23rd March 2022

RE: Covering Statement for a Variation of Conditions application in relation 21/1777/FUL – Residential development of 2 no. dwellings at Land Off Main Street Norton Disney

Drawing Number
J1601d-PL-10

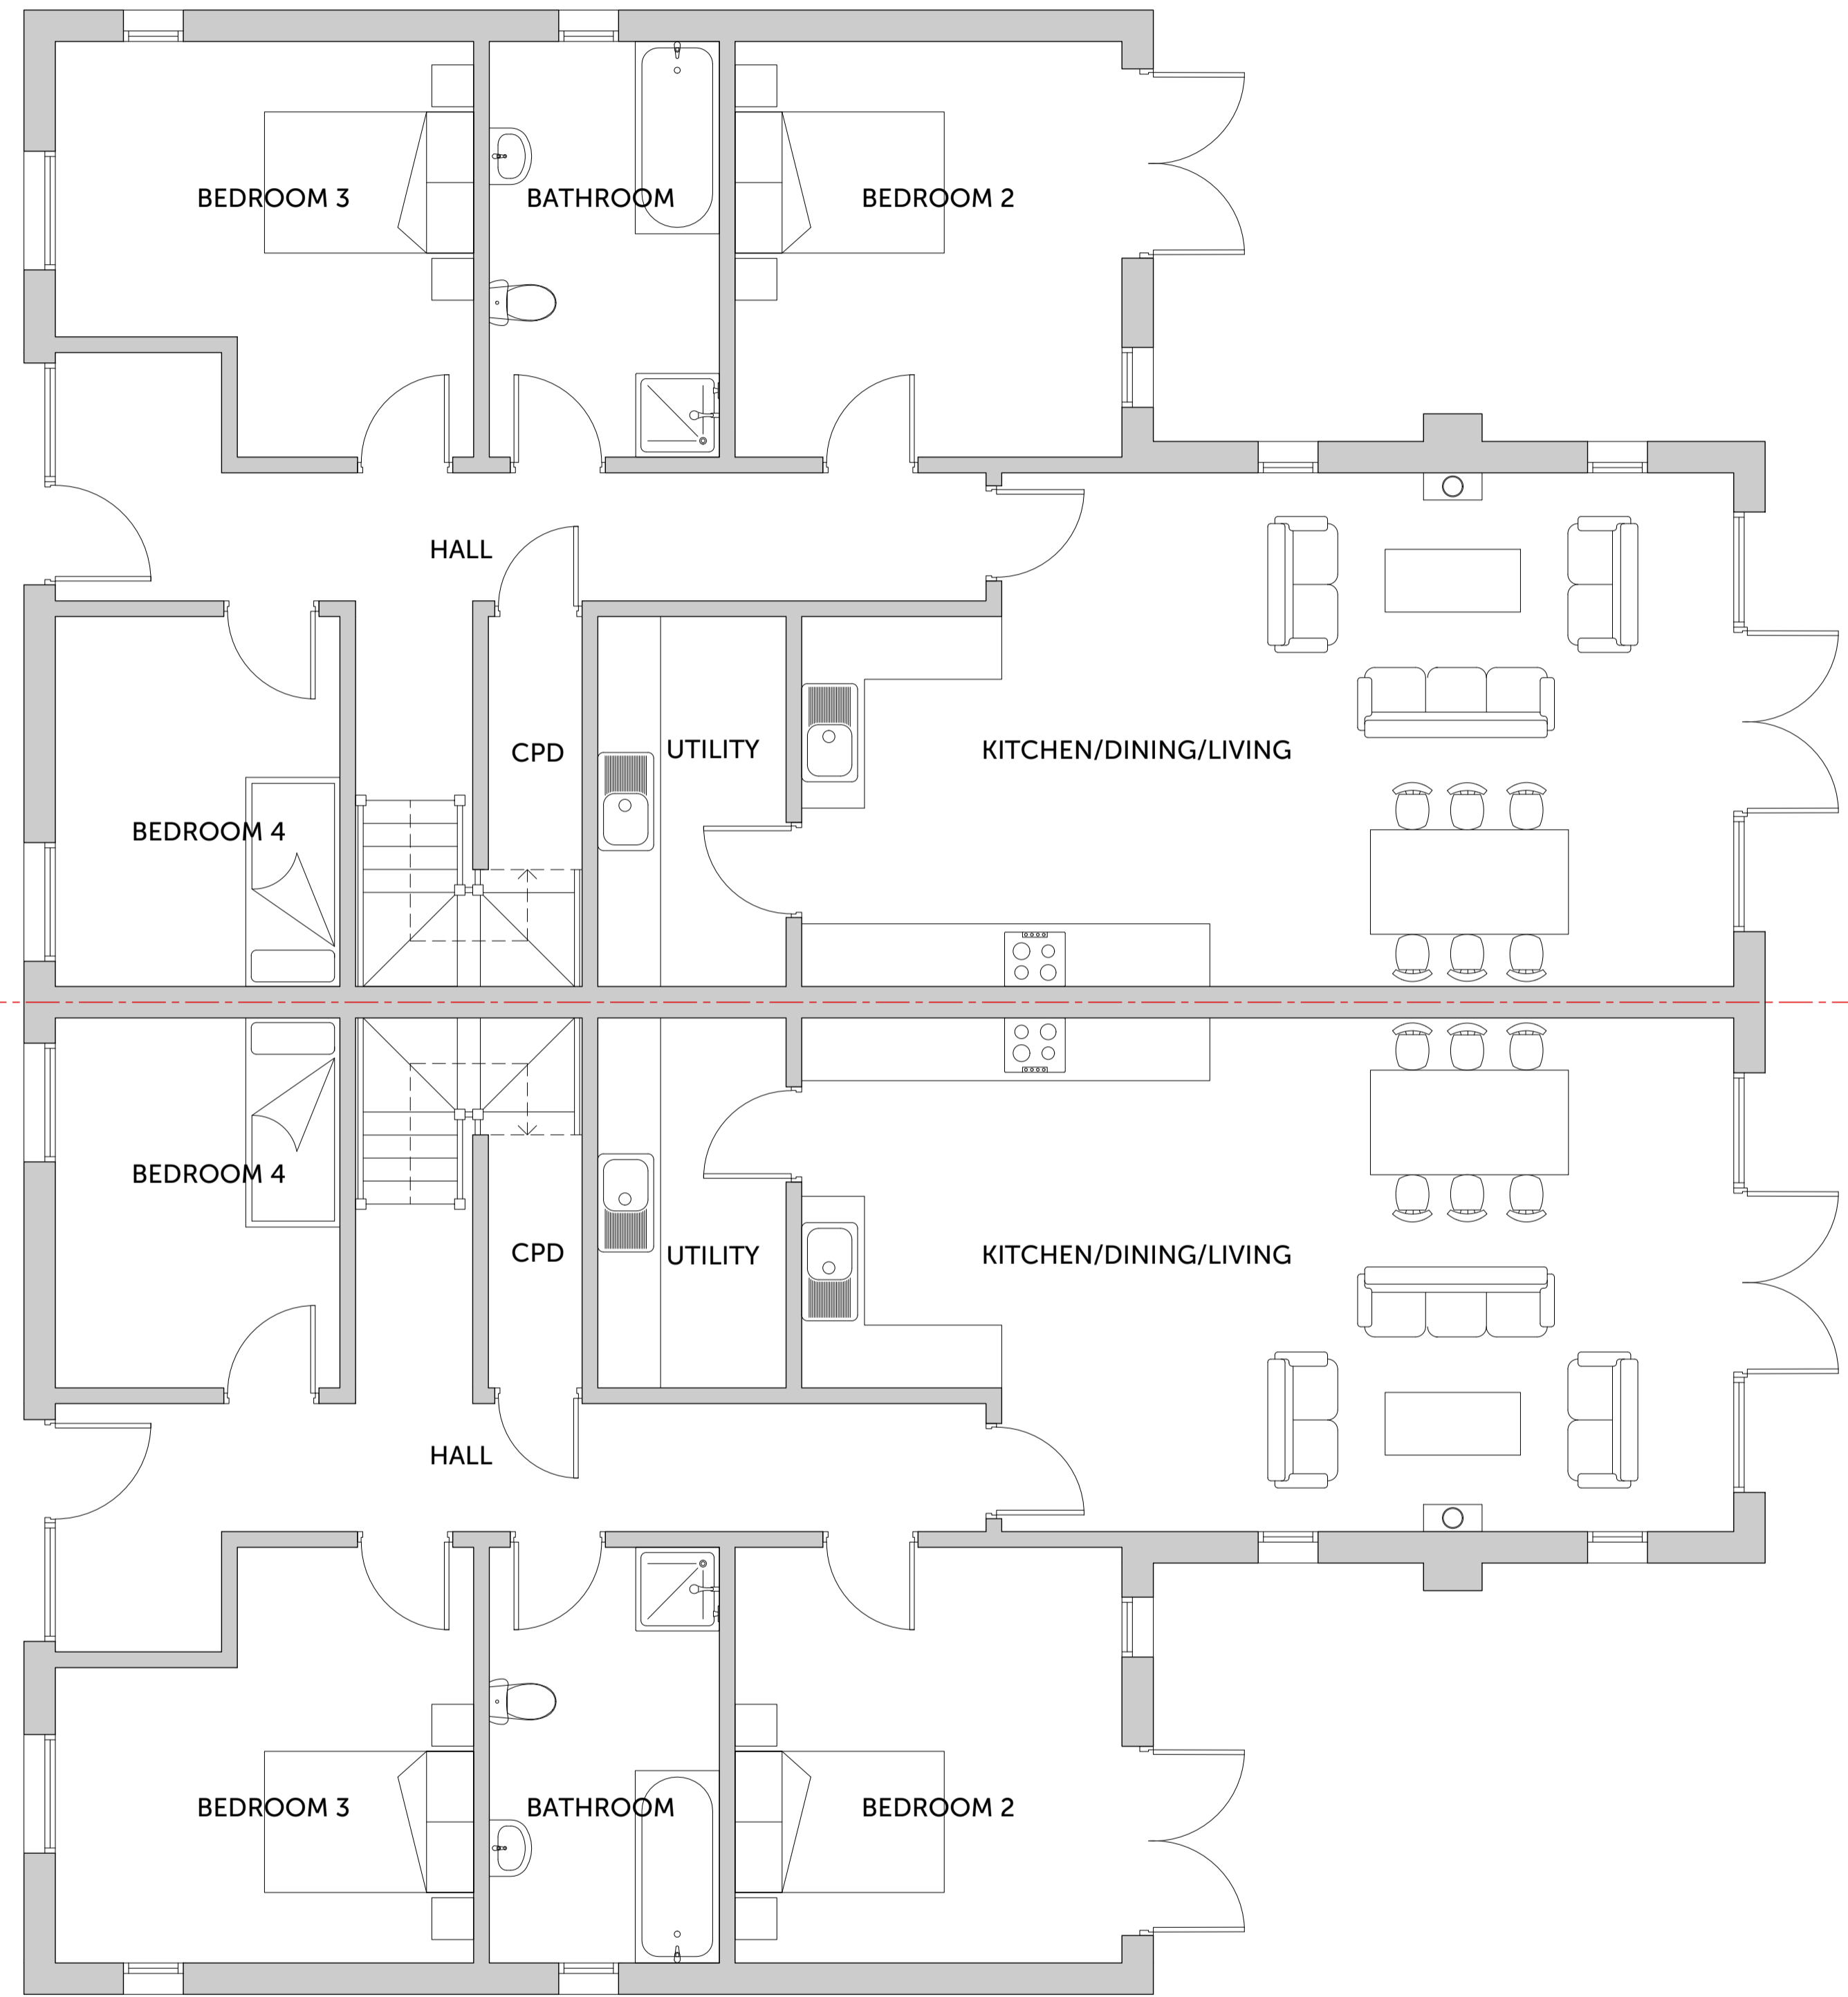
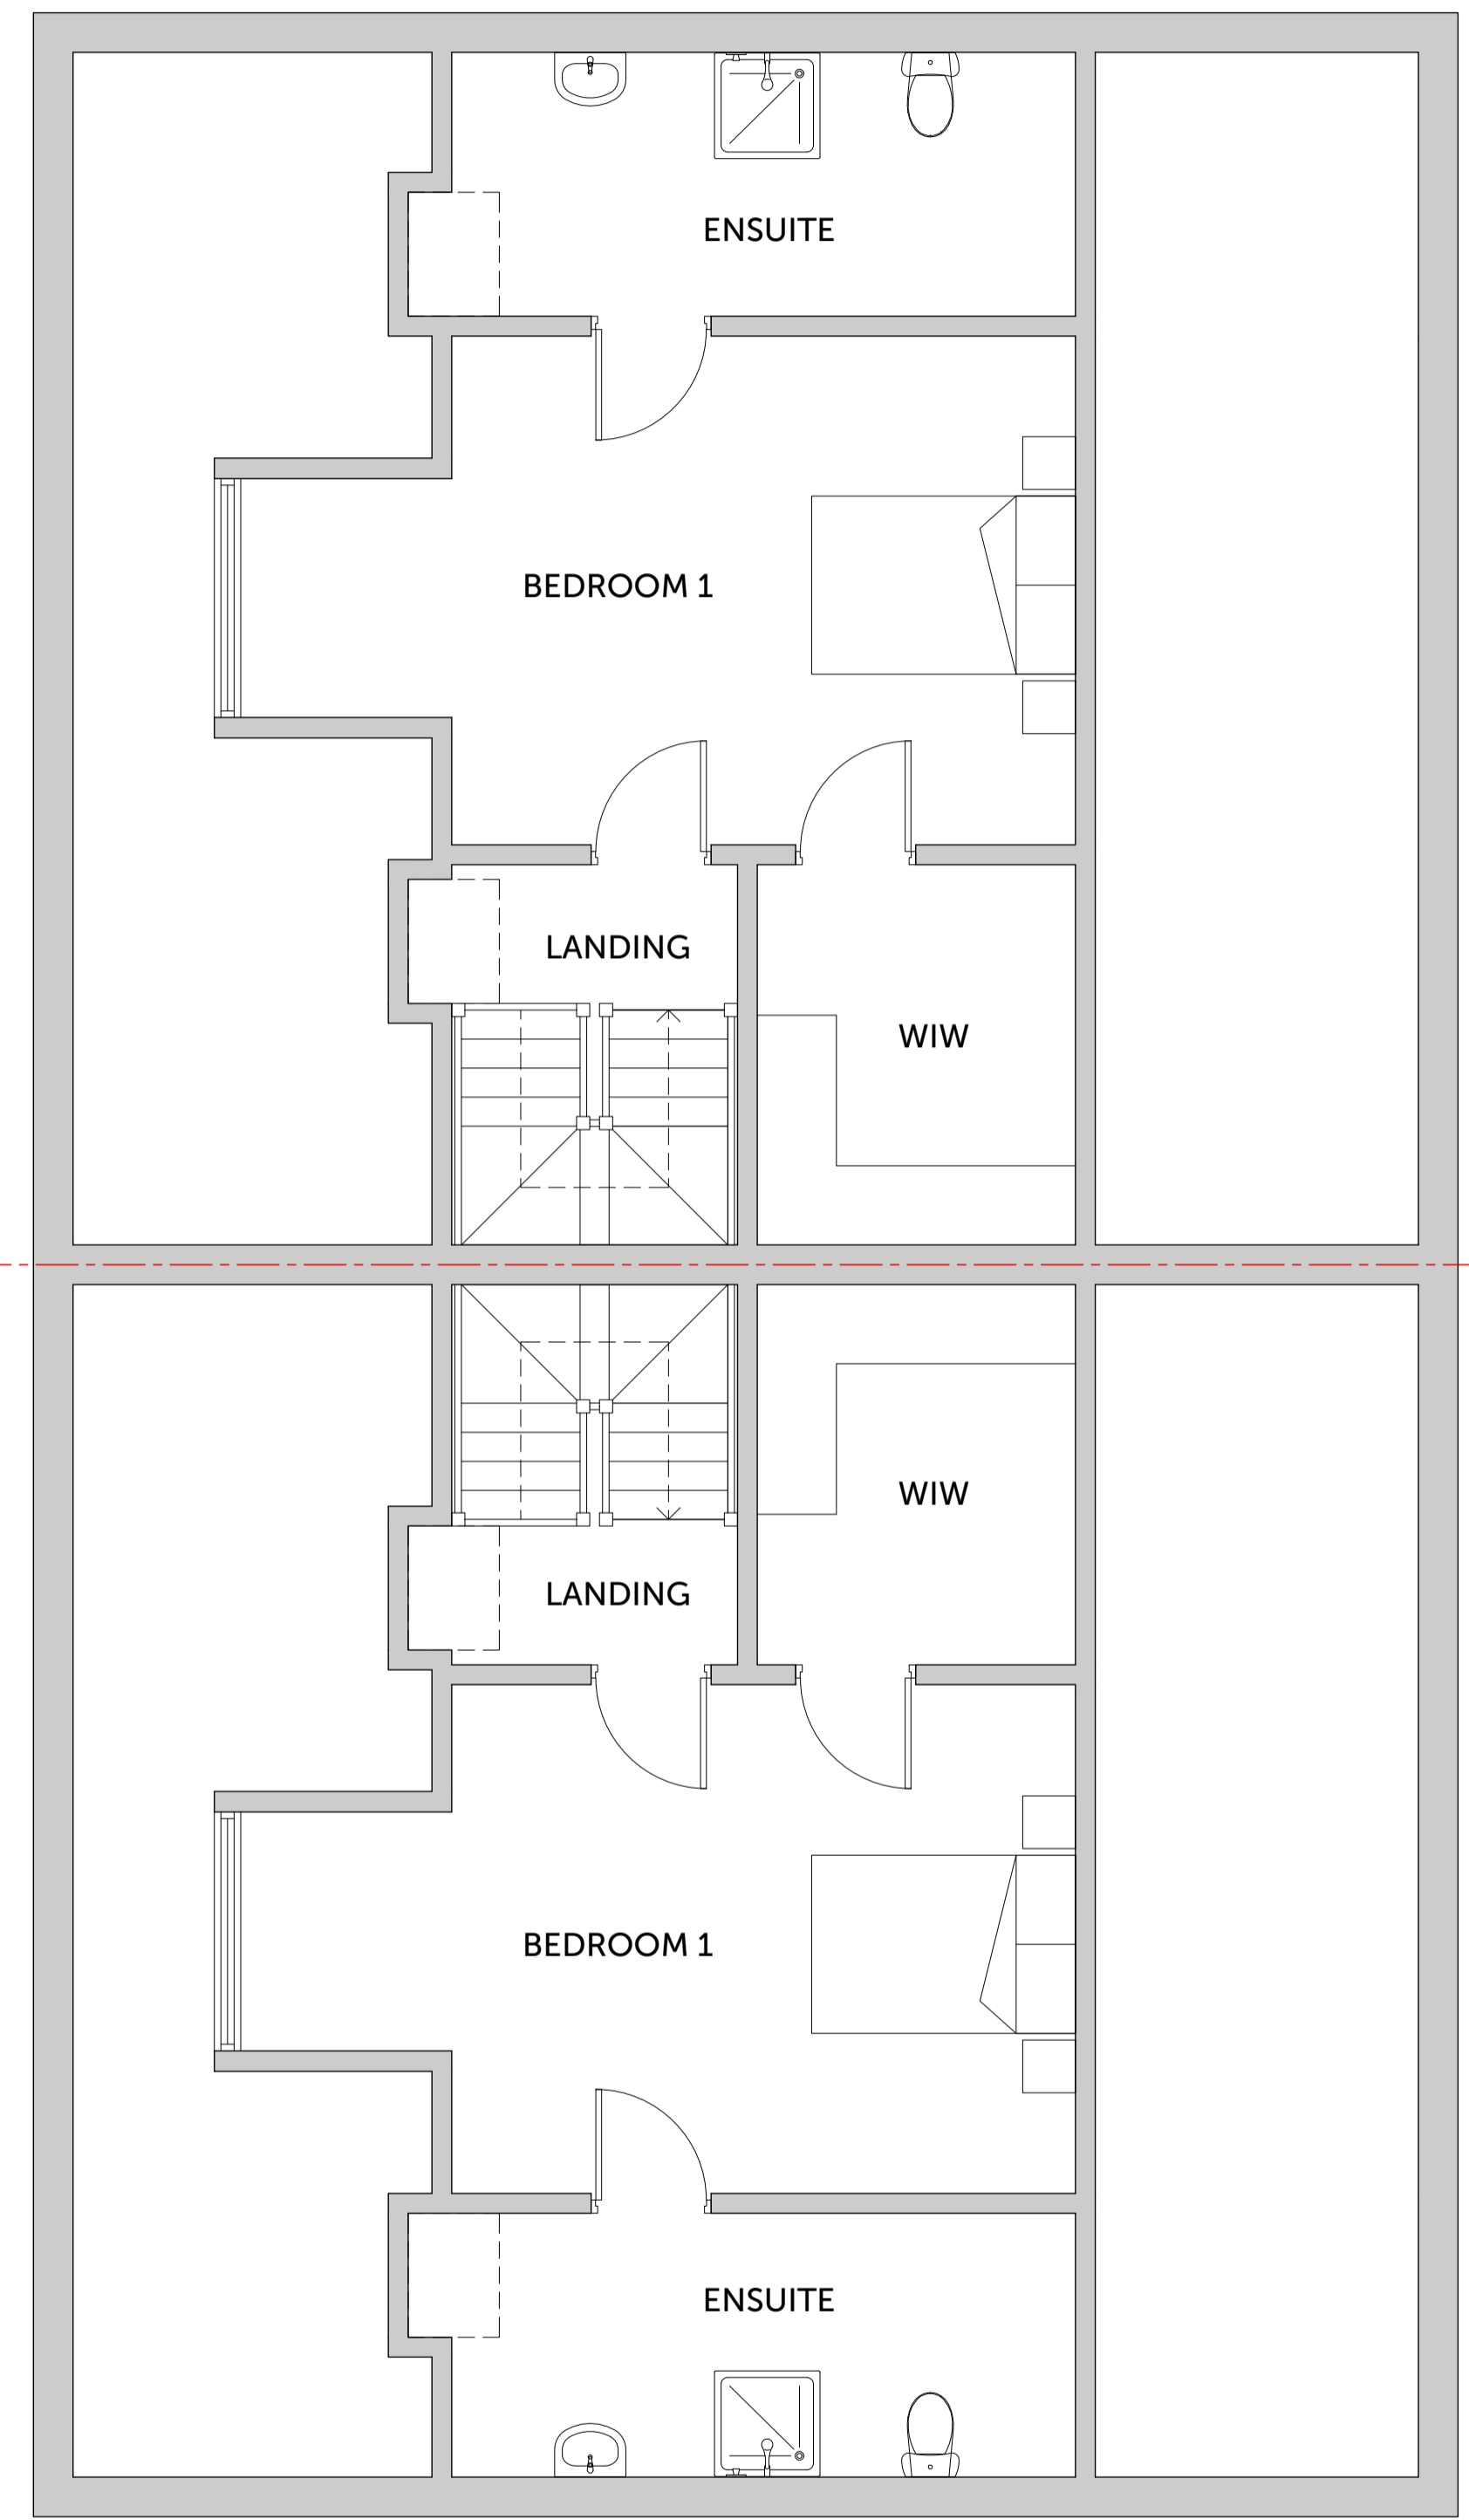
- Internal alterations to include relocating the utility room, addition of ensuite and walk-in-wardrobe to ground floor bedroom, relocation of storage cupboard on ground floor and inclusion of staircase to access first floor (these changes do not alter the elevations)

- Addition of first floor to allow for additional bedroom with ensuite and walk in wardrobe.
